From: Jeff Watson
Sent: Tuesday, June 25, 2013 12:41 PM
To: Christina Wollman; Brenda Larsen; Jan Ollivier; Holly Duncan; Erin Moore
Subject: BL-13-00012 Buress

[BL-13-00012 Buress](#)

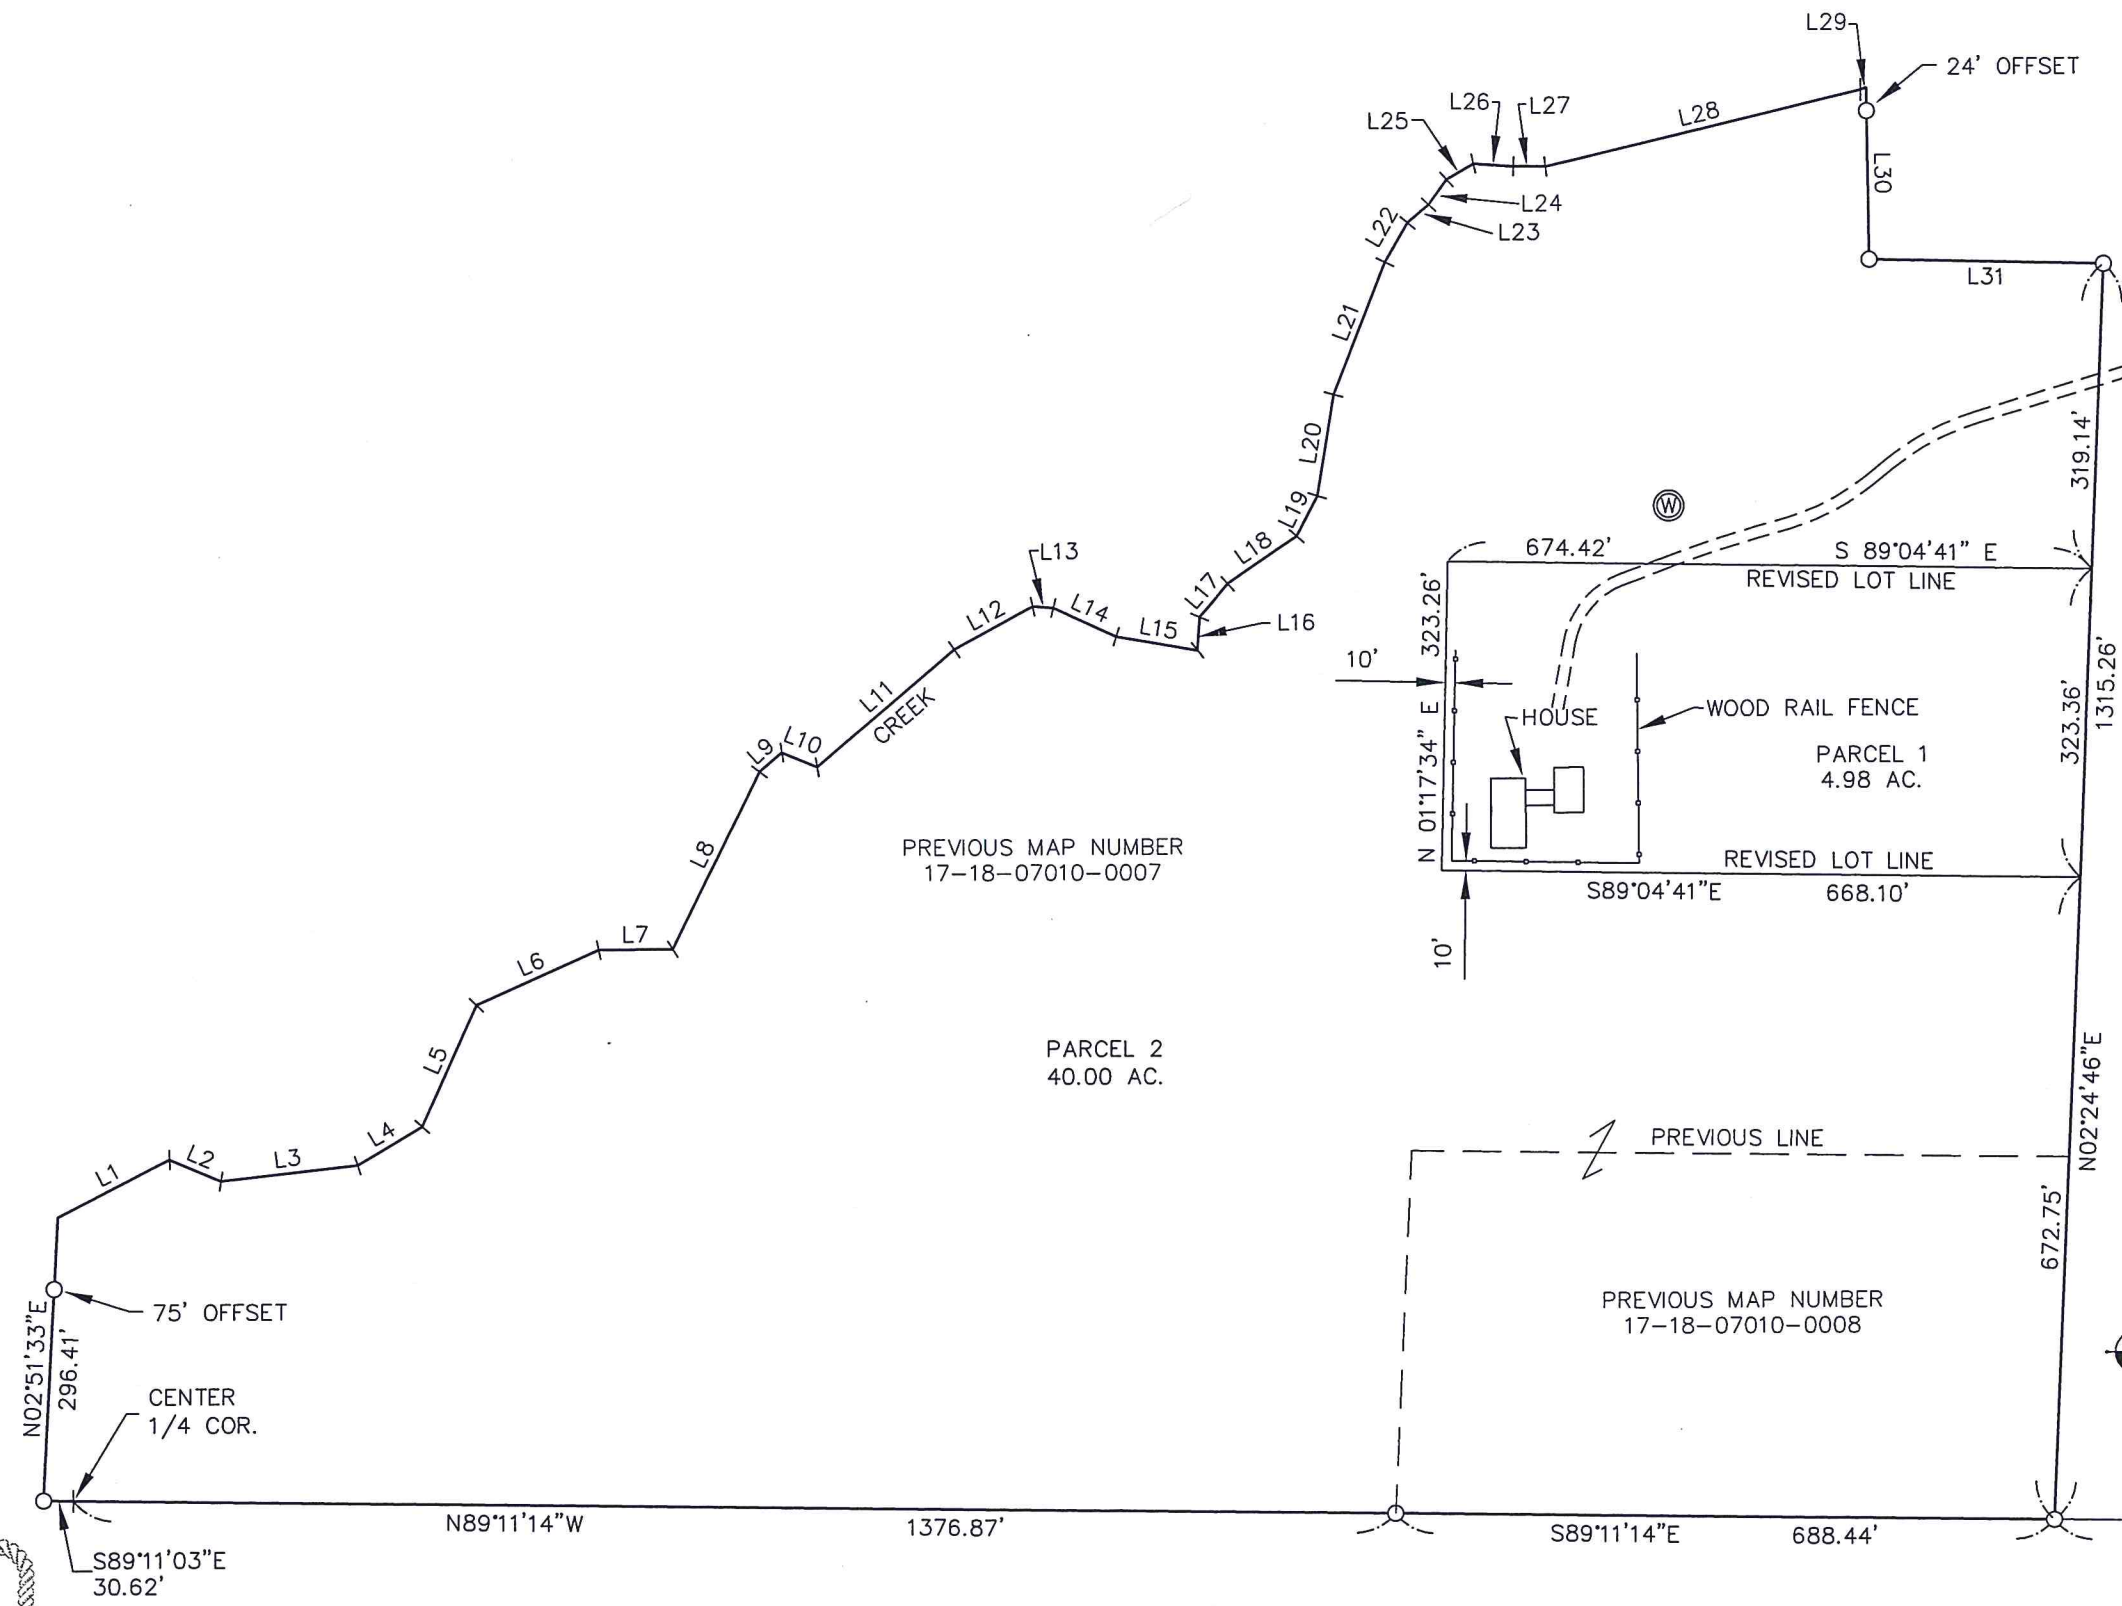
I see it has a denial letter in the file. Either way the only thing that stands out at me is that we need to be sure the well is 50 feet from the property line. Another thing that comes to mind is whether or not it will be a shared well since it is not on the same lot as the home.
